From: [REDACTED]
Sent: 06 February 2012 14:03
To: Susan Leeson
Subject: Butterlees Farm P/92/11 WSCC Ecology
Attachments: P9211(ECO).doc

APPLICATION No.: DC/92/11/952/DOC

PROPOSAL: Application for approval of details reserved by conditions 3 & 6 relating to P/145/08/ for Conversion of C-19th flint barn to 4 bedroom house and self contained one bedroom holiday let & landscaping

SITE: Land to the north of Highfield, Stane Street, Pulborough

BUTTERFLIES BARN & LISSNESS
BARN & TYRE GROUND FLOOR PLAN AS PROPOSED
DWG/307/D-05F 1:1000 AS JUL 2008
MALCOLM SIMMONDS ARCHITECTS

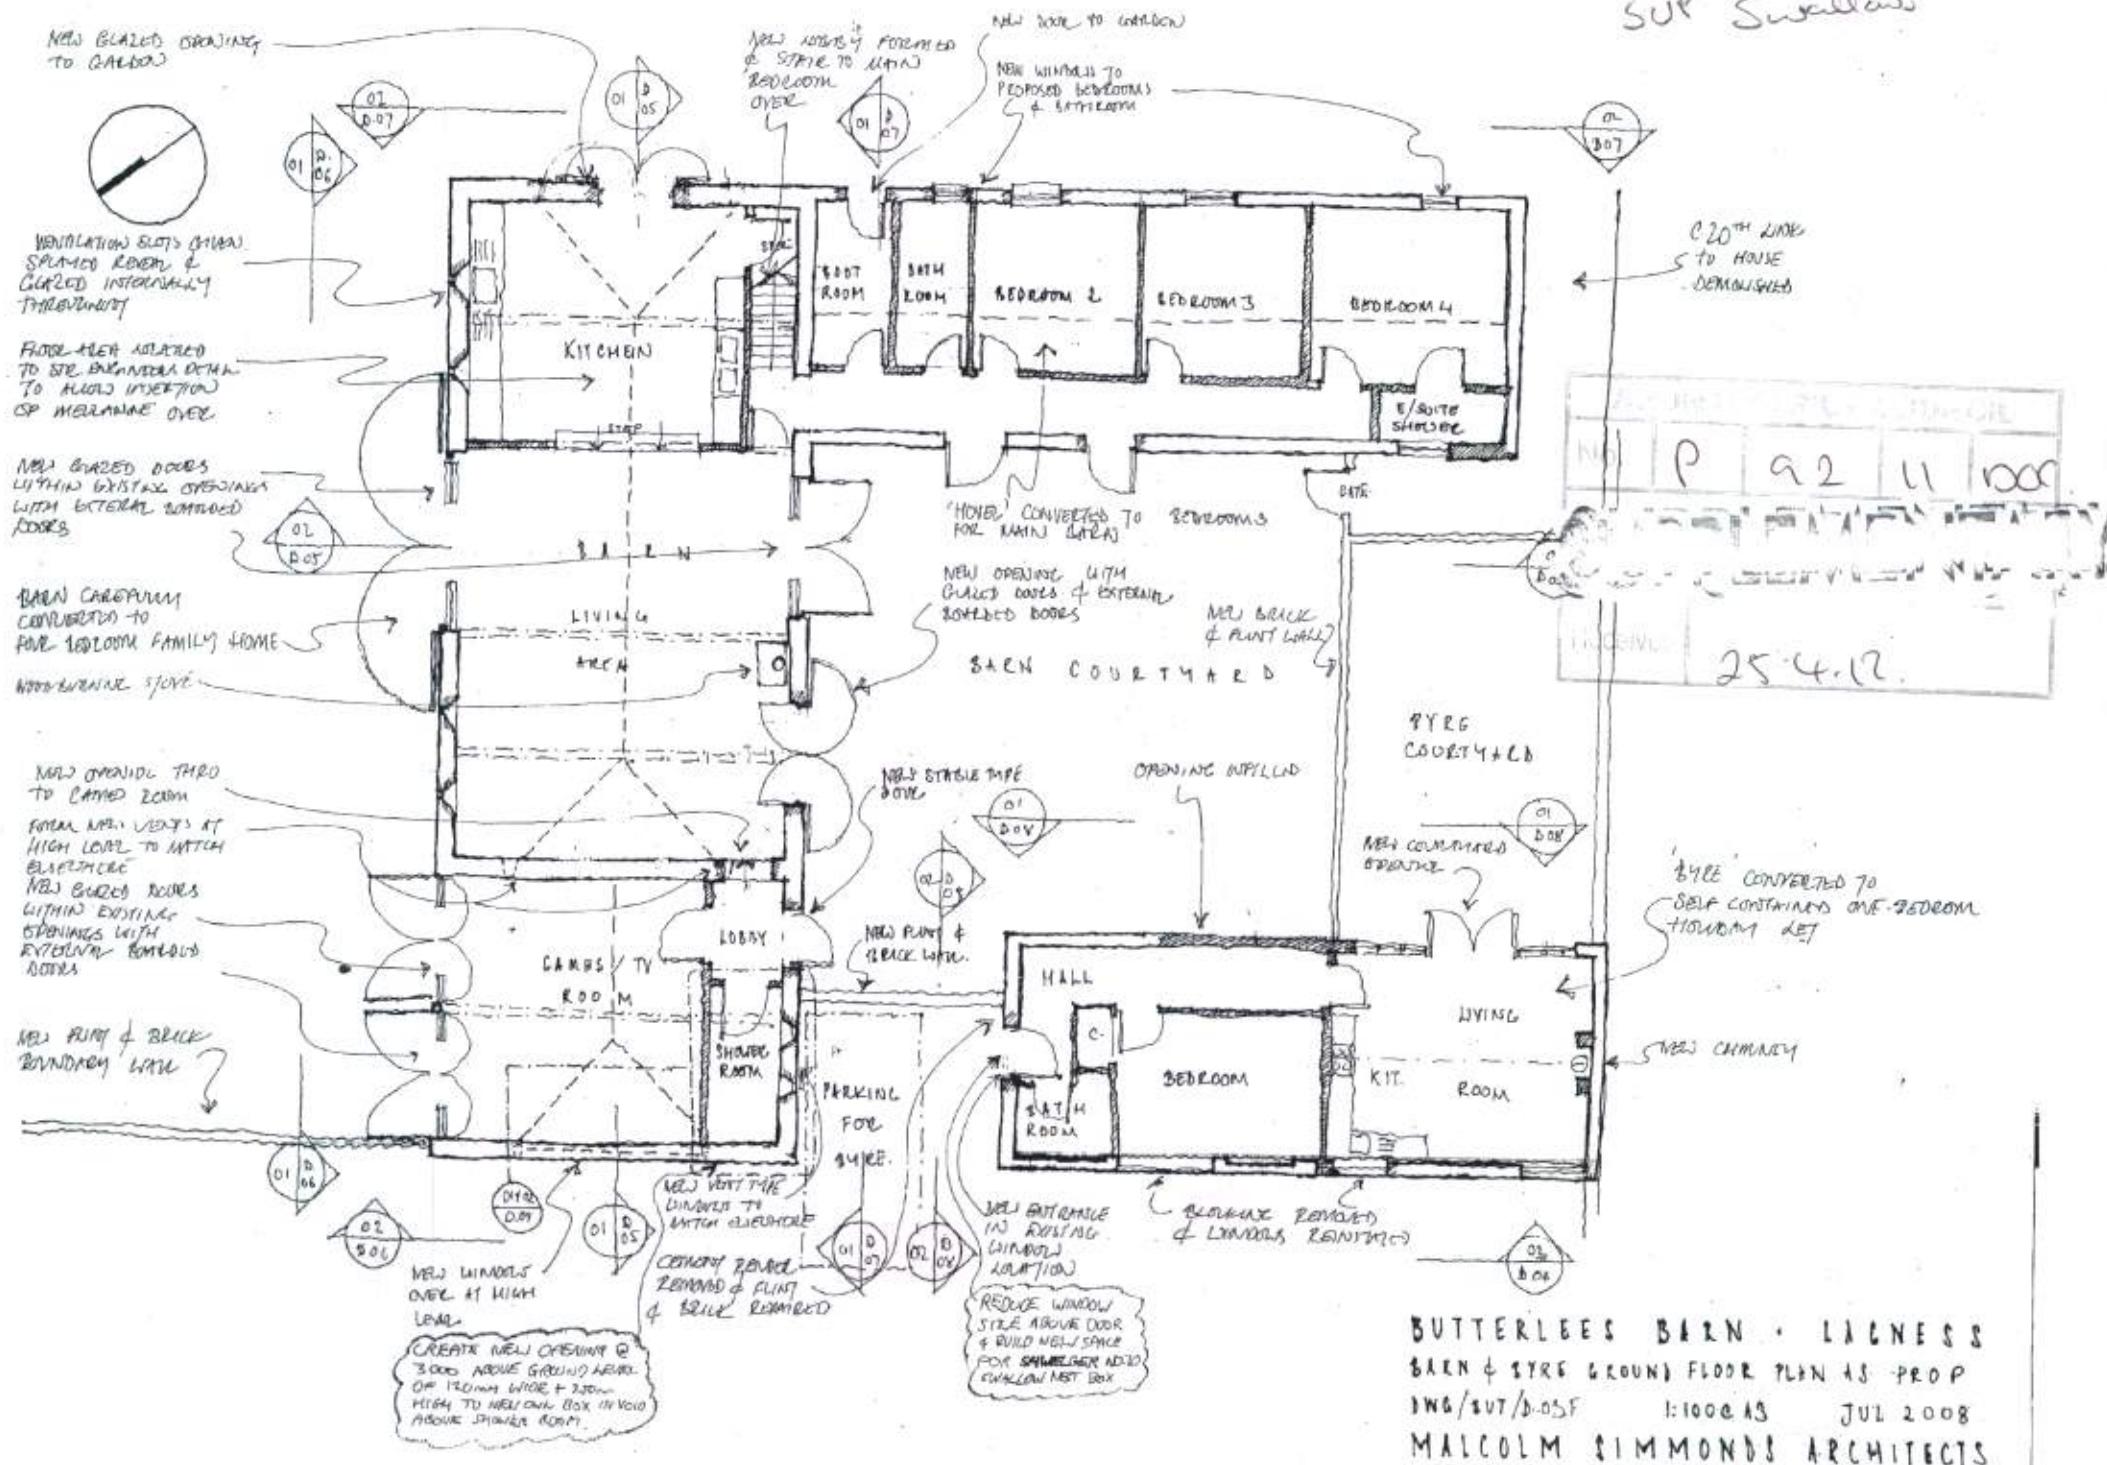
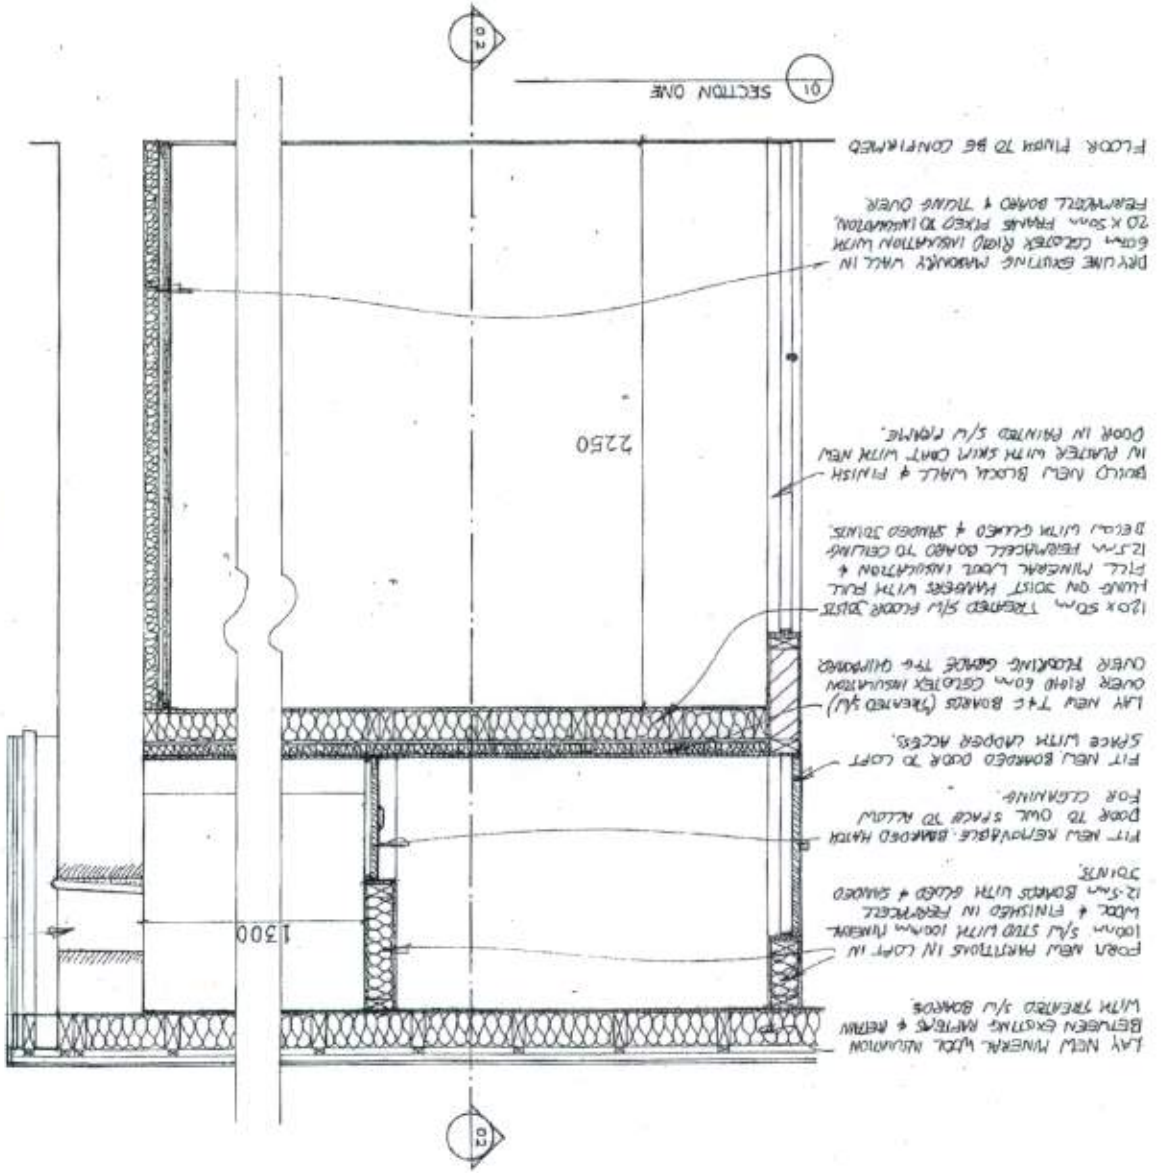
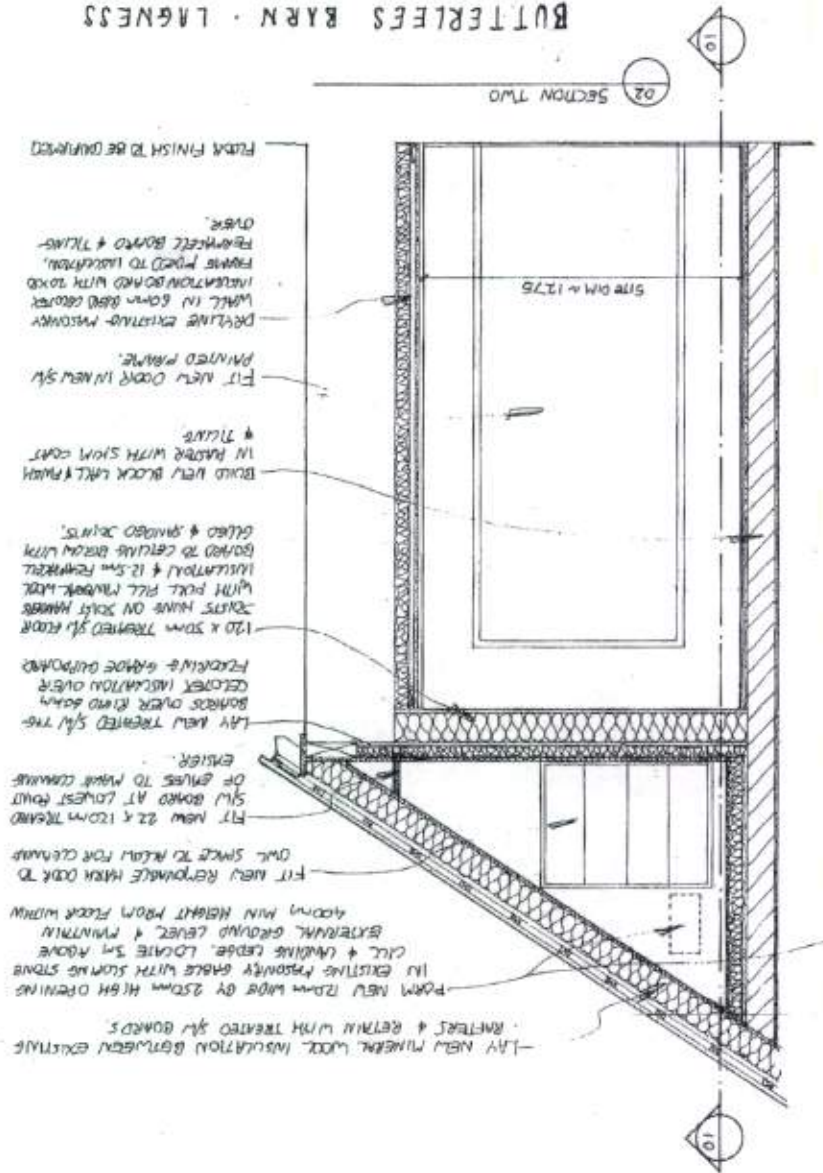
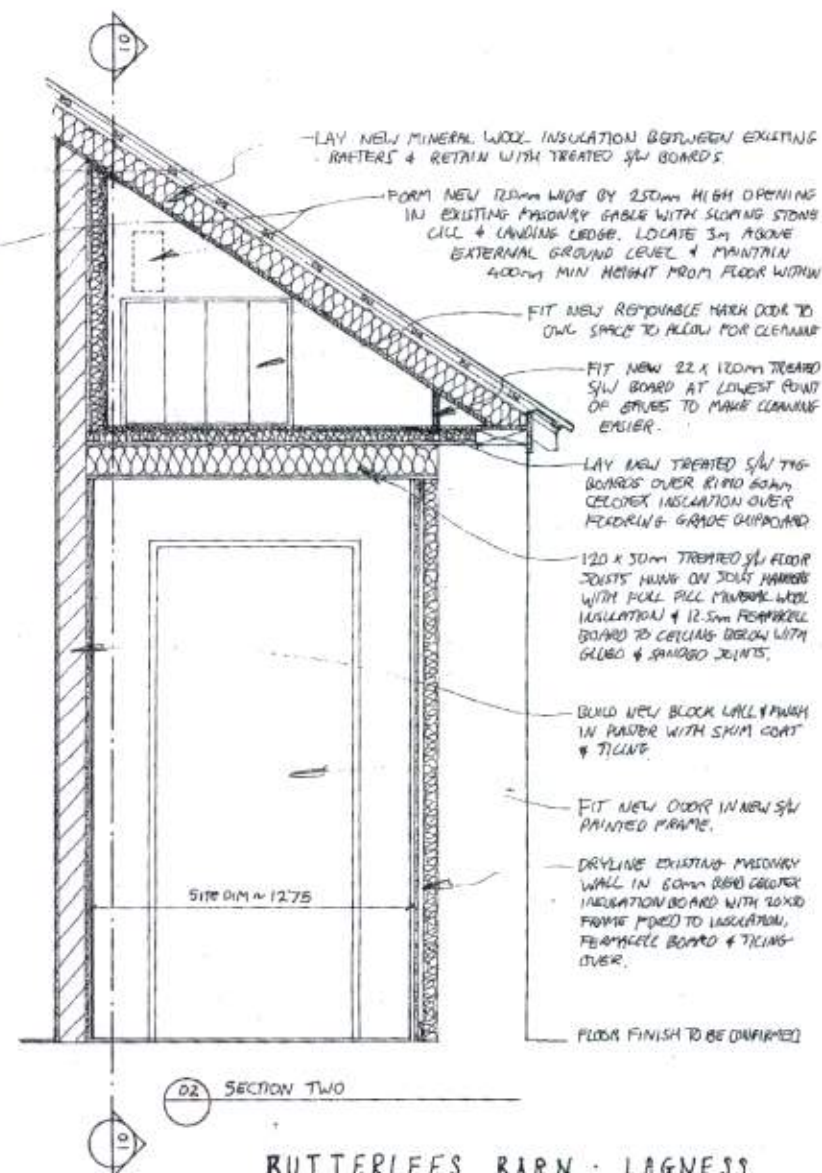
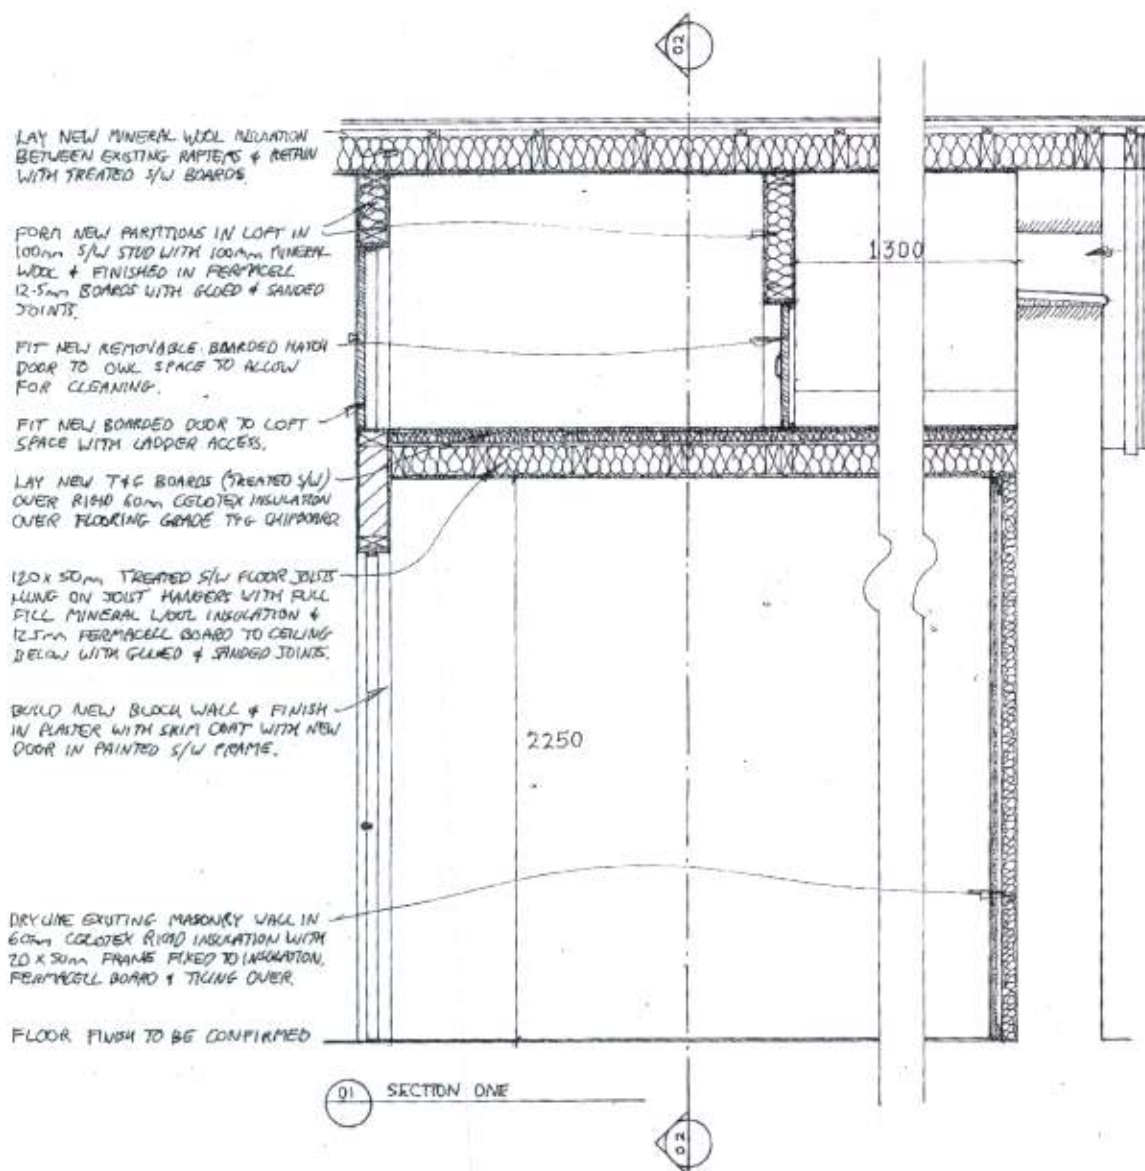
Subject to the erection of either an EcoSurv bat box or a Schweglar 1FR bat tube situated on the South / South West aspect of the buildings. Access and nesting provision (e.g. Schweglar No. 10) for swallows should be maintained.
